## **Response to Submissions State Significant Development 6407**

### **Fifteenth Avenue Commercial Precinct**

### **185 & 195 Fifteenth Avenue, West Hoxton**

Prepared by Willowtree Planning Pty Ltd on behalf of  
Western Sydney Parklands Trust

DRAWING No. **C011995.00- DA30** ISSUE **D**

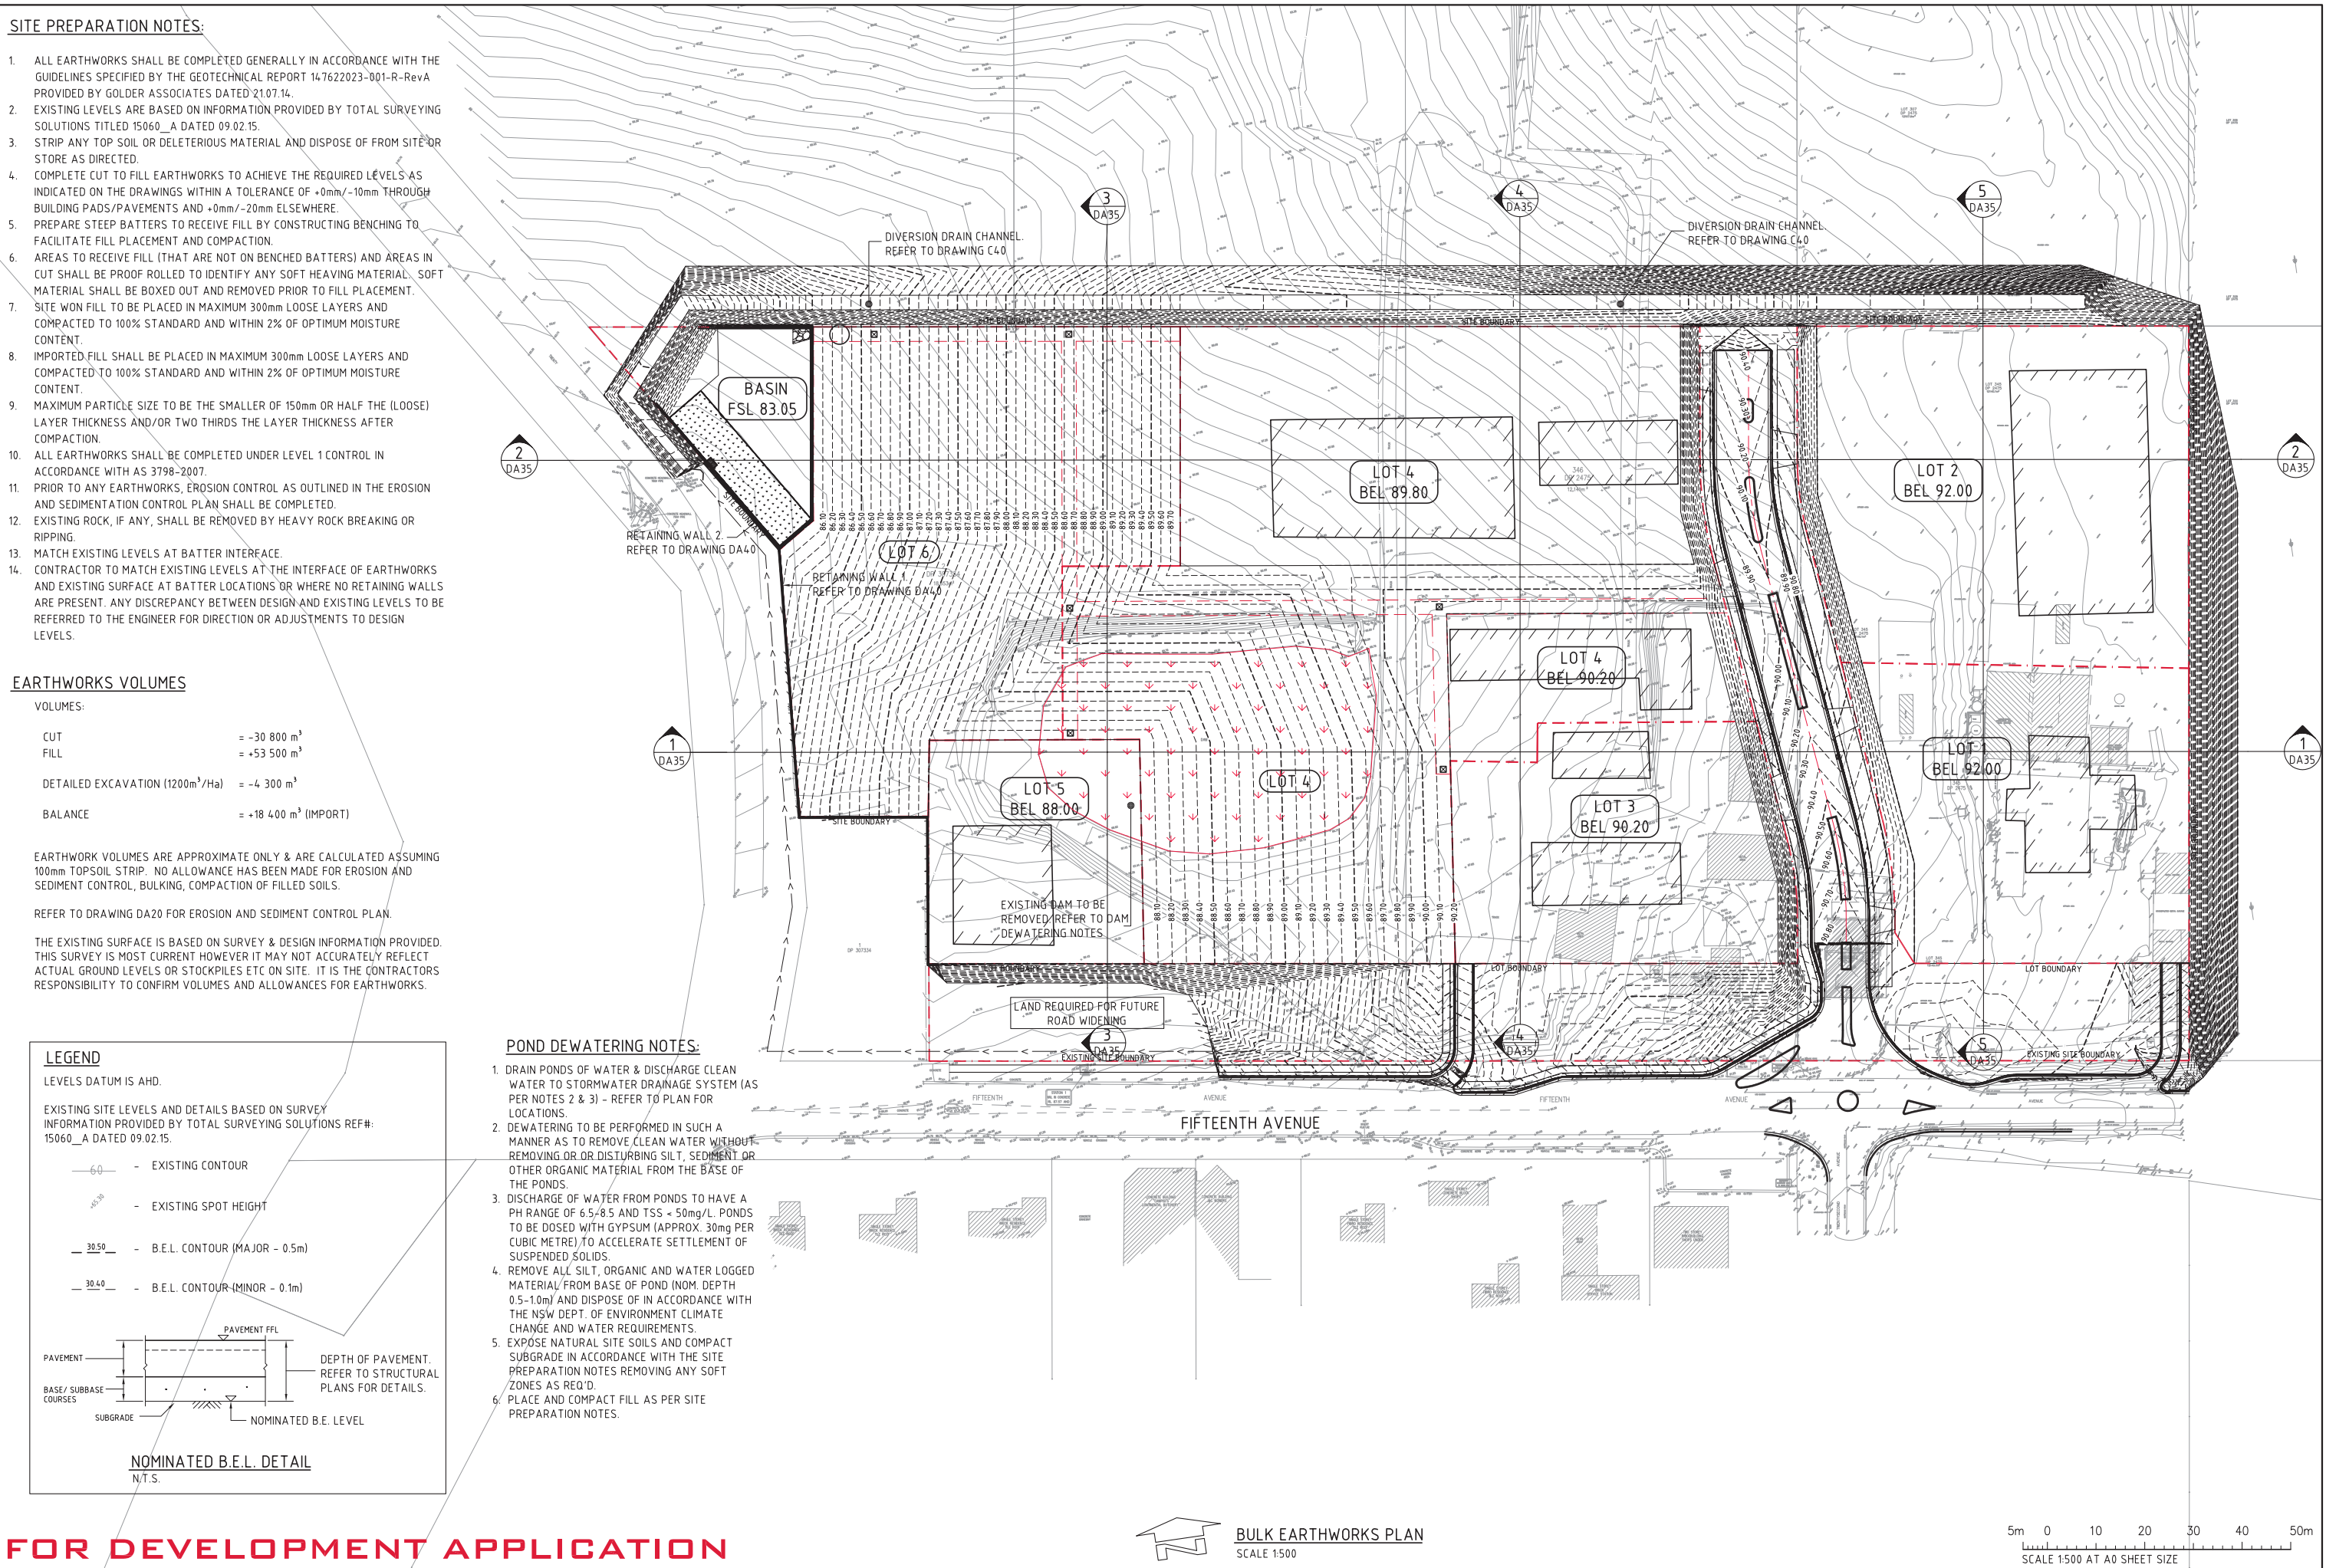
<i>Details should be provided on how the two dams will be emptied and filled in, as per the comments by Department of Primary Industries – Water.</i>	A detailed note on dewatering and filling can be found within Costin Roe's originally lodged Civil Works Plans on Drawing No. CO11995.00-DA30 Rev D.

FIGURE 13: Indicative Staging Plan

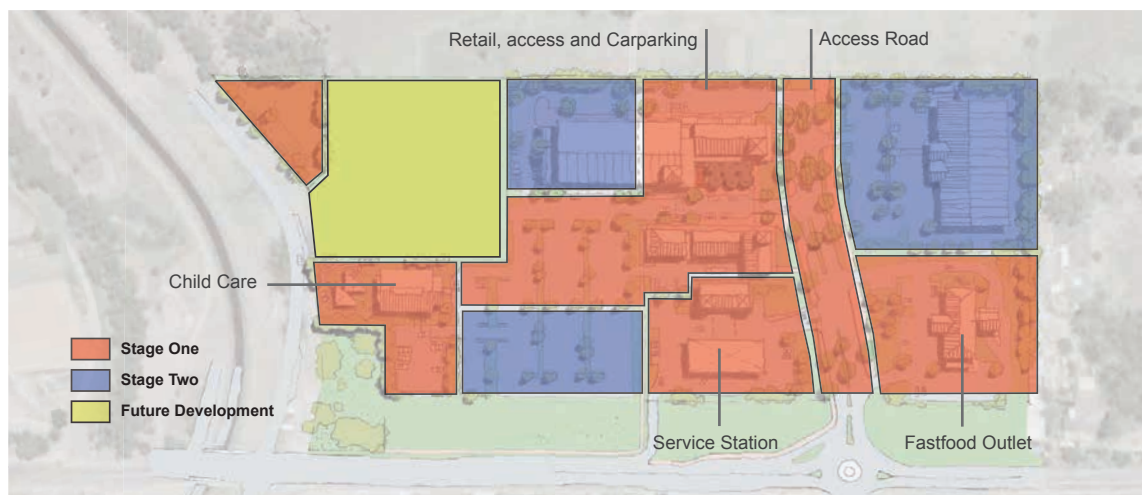
<i>A plan should be provided showing the indicative phasing of the development, and in particular showing subsequent phases to those proposed in figure 28 of the urban design report.</i>	LFA's revised Urban Design Report ( <b>Appendix 2</b> ) includes an amended Indicative Staging Plan (Figure 14) to demonstrate the phasing of the development within Stage 1 of the staged proposal. It is noted that the site could be developed in a single stage or a series of stages dependent on market response and demand.
<i>Operational noise impacts</i>	<i>The Operational Noise Impact Assessment (Appendix 22) should be updated to address the Environmental Protection Authority's concerns regarding the identification of background noise and consider the potential noise impacts of any 24 hour operations / uses, such as the service station.</i>	Section 3 of Acoustic Logics response ( <b>Appendix 5</b> ) addresses the EPA's concerns in regards to operational noise. Furthermore the Operational Noise Impact Assessment ( <b>Appendix 6</b> ) has been revised to address some of these matters.
